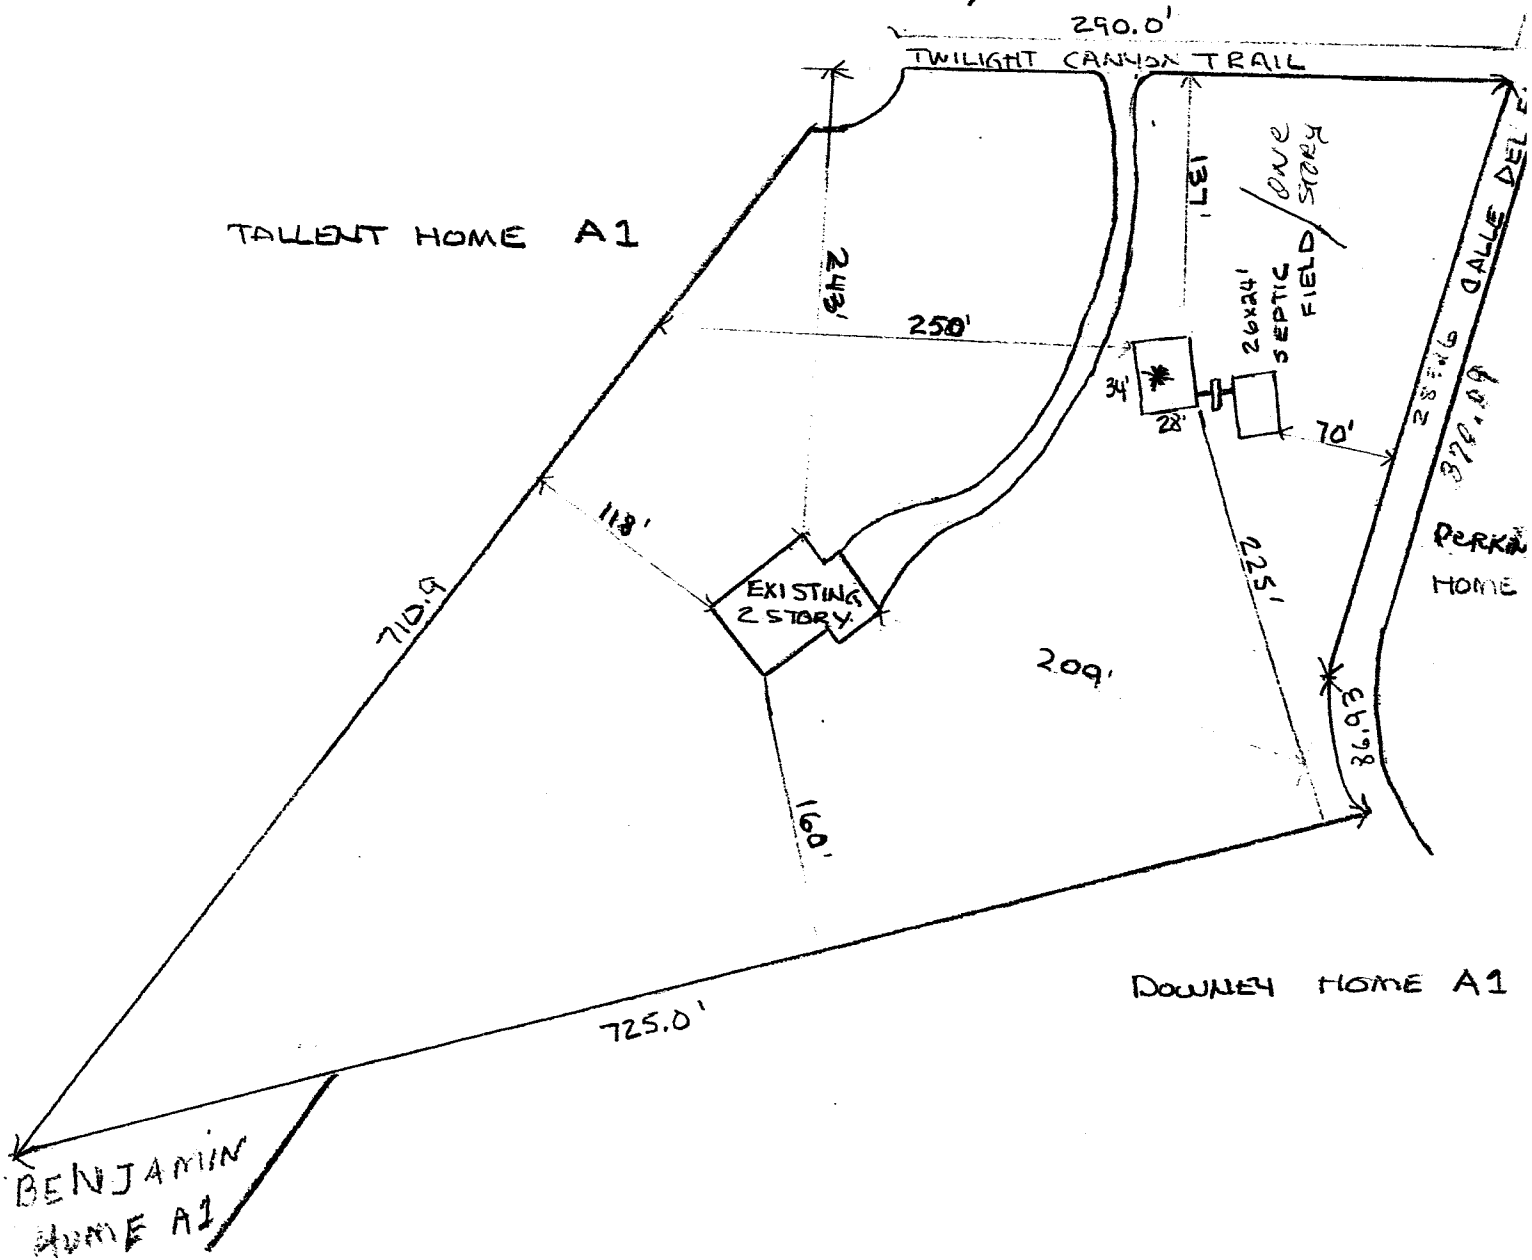
Per the early assistance meeting the applicant indicated that the second access located at the cul-de-sac was to be closed. Please show the access on the Site Plan and label the access "To be closed with this application" as discussed in the early assistance meeting.

Is this the guest house? If so mark it as such.
